**From:** Laura Gibbons <Laura.Gibbons@arun.gov.uk>  
**Sent:** 07 October 2019 16:15  
**To:** Planning.Responses <Planning.Responses@arun.gov.uk>  
**Cc:** Michael Eastham <Michael.Eastham@arun.gov.uk>  
**Subject:** RE: Planning Consultation on BN/85/19/DOC

Engineers Comments Regarding Condition 6

**APPLICATION NO:** BN/85/19/DOC

**Site Address:** Land Rear of Lillies Yapton Road Barnham PO22 0AY

REV	DESCRIPTION	DRN	CHD	DATE
☒ PRELIMINARY	☐ INFORMATION	☐ TENDER		
☐ CONSTRUCTION	☐ AS BUILT			
SCALE	1:200 @ A1	DATE	JULY 2019	
DRAWN	WFN	CHK	CLS	
DRAWING NO.	17748-BARN-5-600	REV	-	
TITLE	YAPTON ROAD BARNHAM			
DETAILS	ENGINEERING LAYOUT SHEET 1

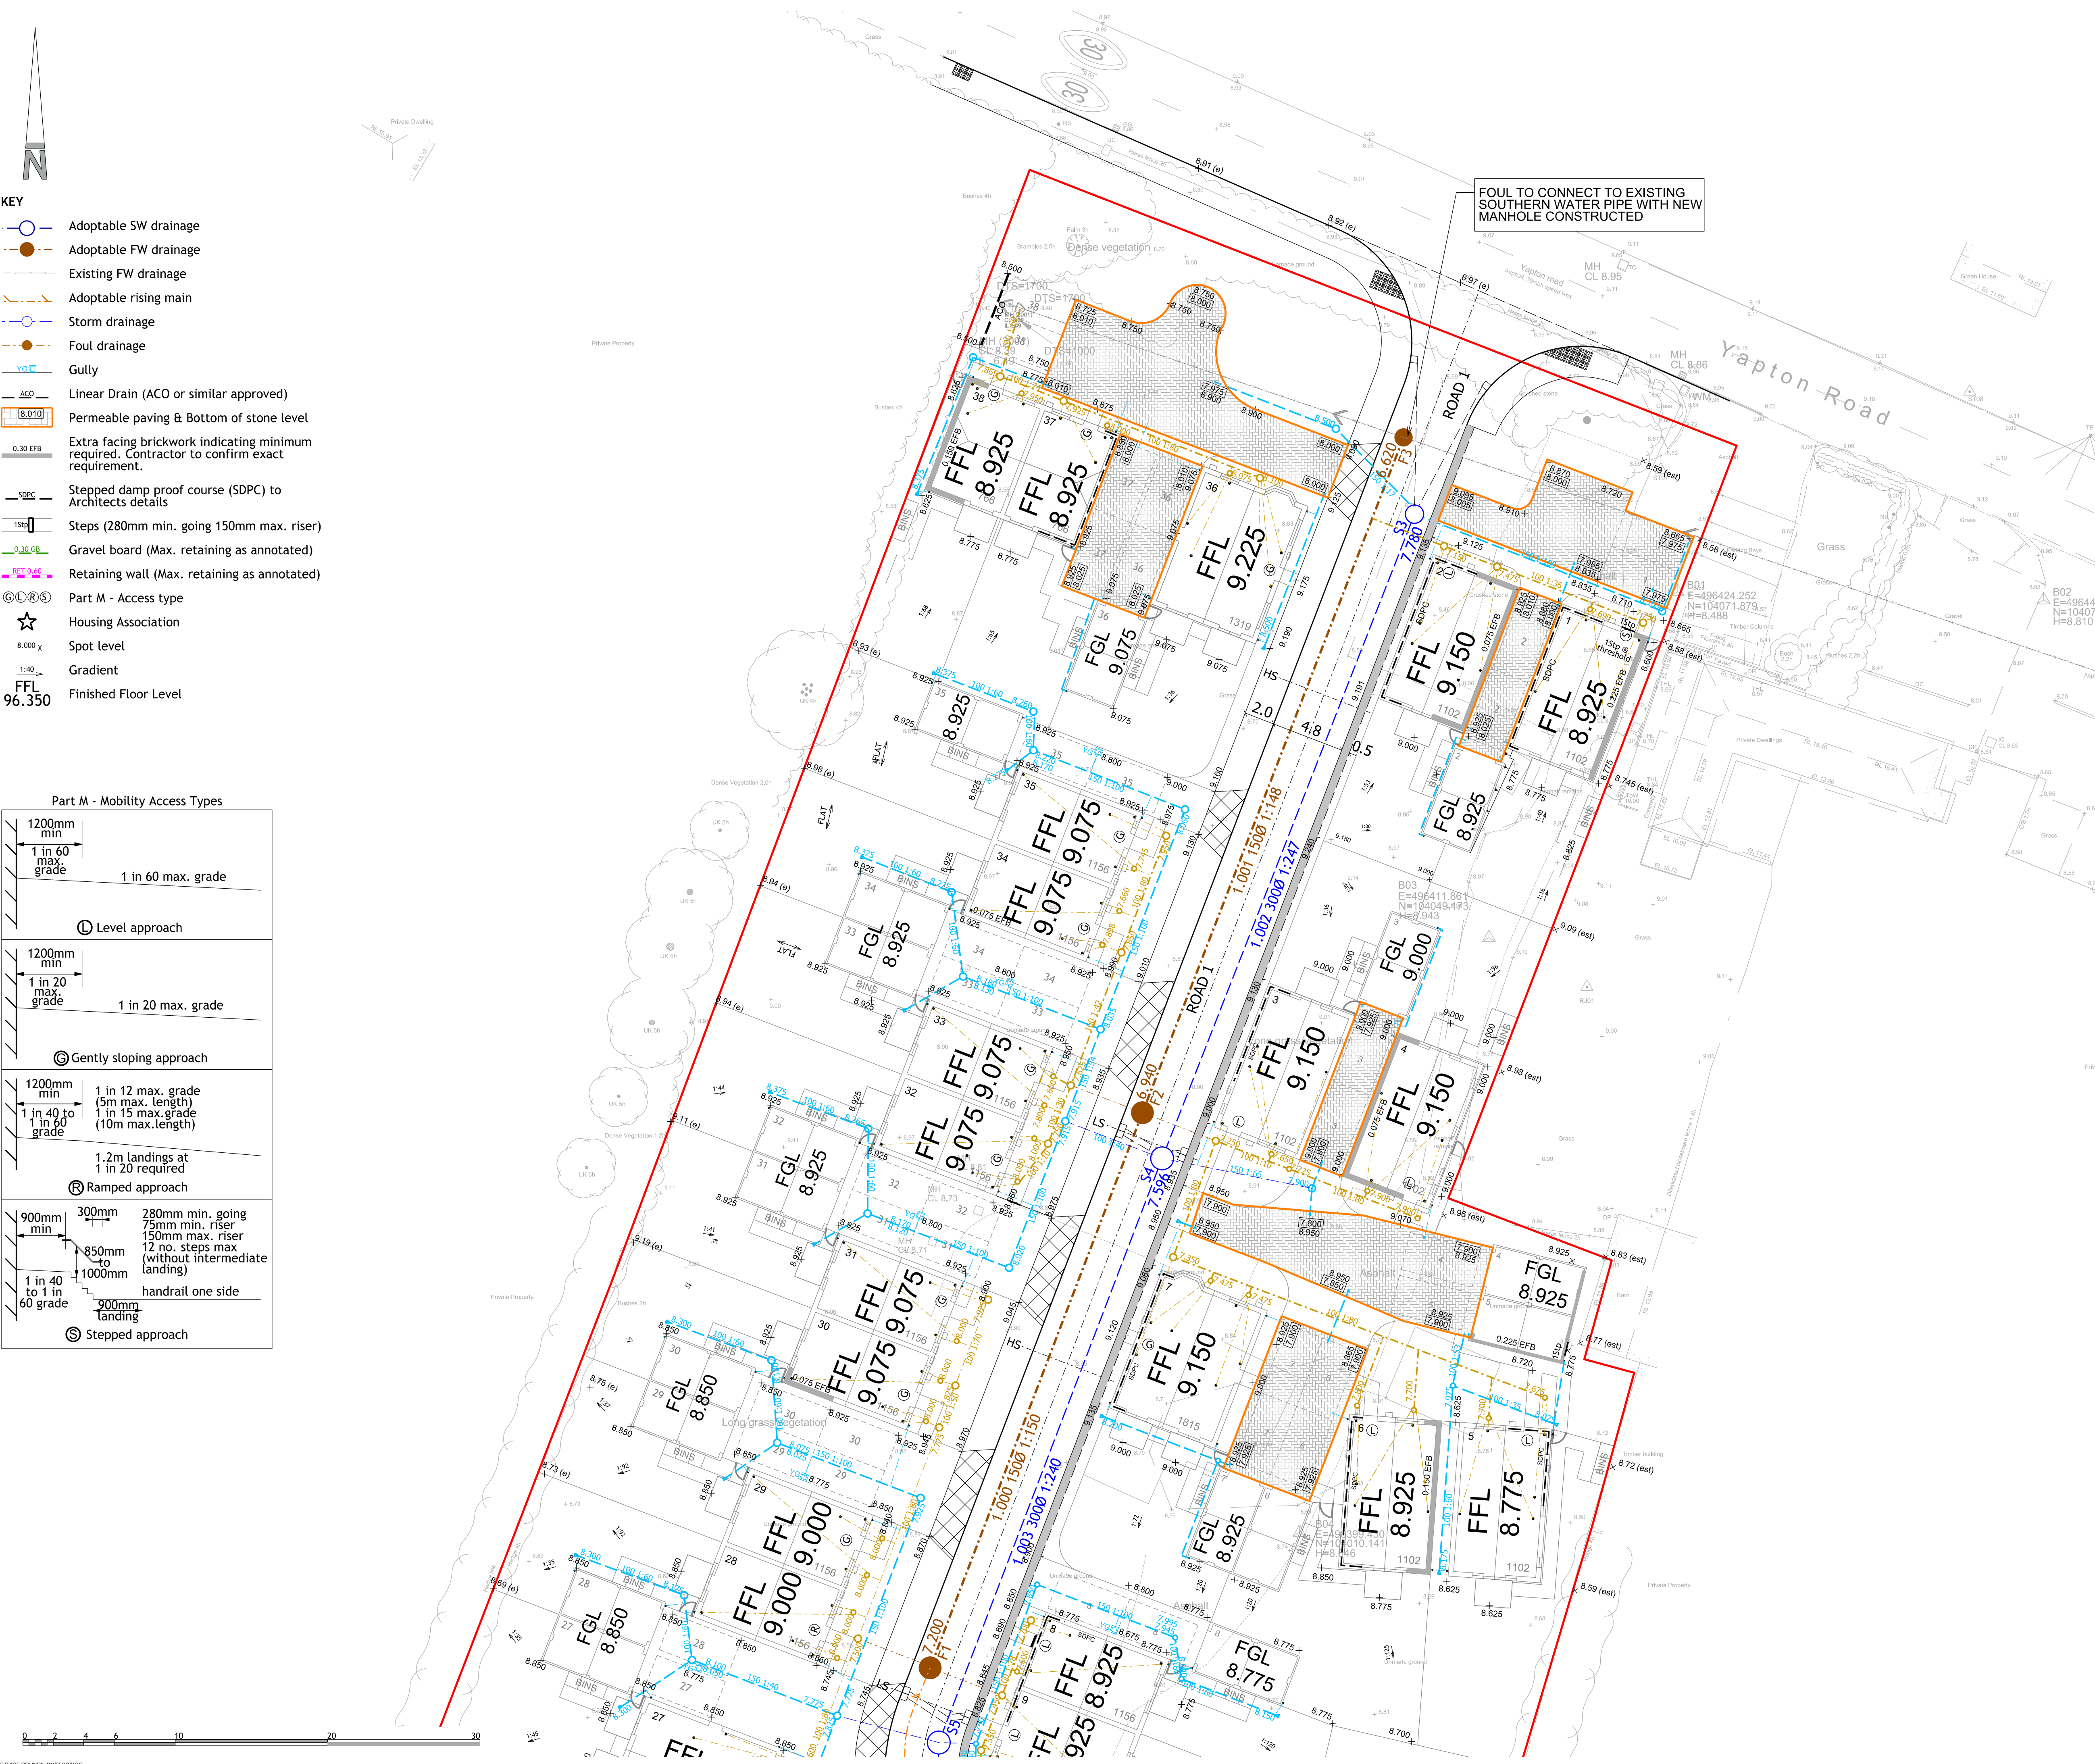
6. The proposed invert level of any outfalls must clearly be shown on plan with hard and soft ditch bed levels also provided.
7. The proposed attenuation basin has inadequate easement around it and to the watercourse. 3m easement must be provided around the attenuation basin and to the watercourse.

8. Proposed side slopes of basins must be stated on the layout drawing and construction detail drawing.
9. Finish and formation levels of permeable paving must be clearly stated on plan.
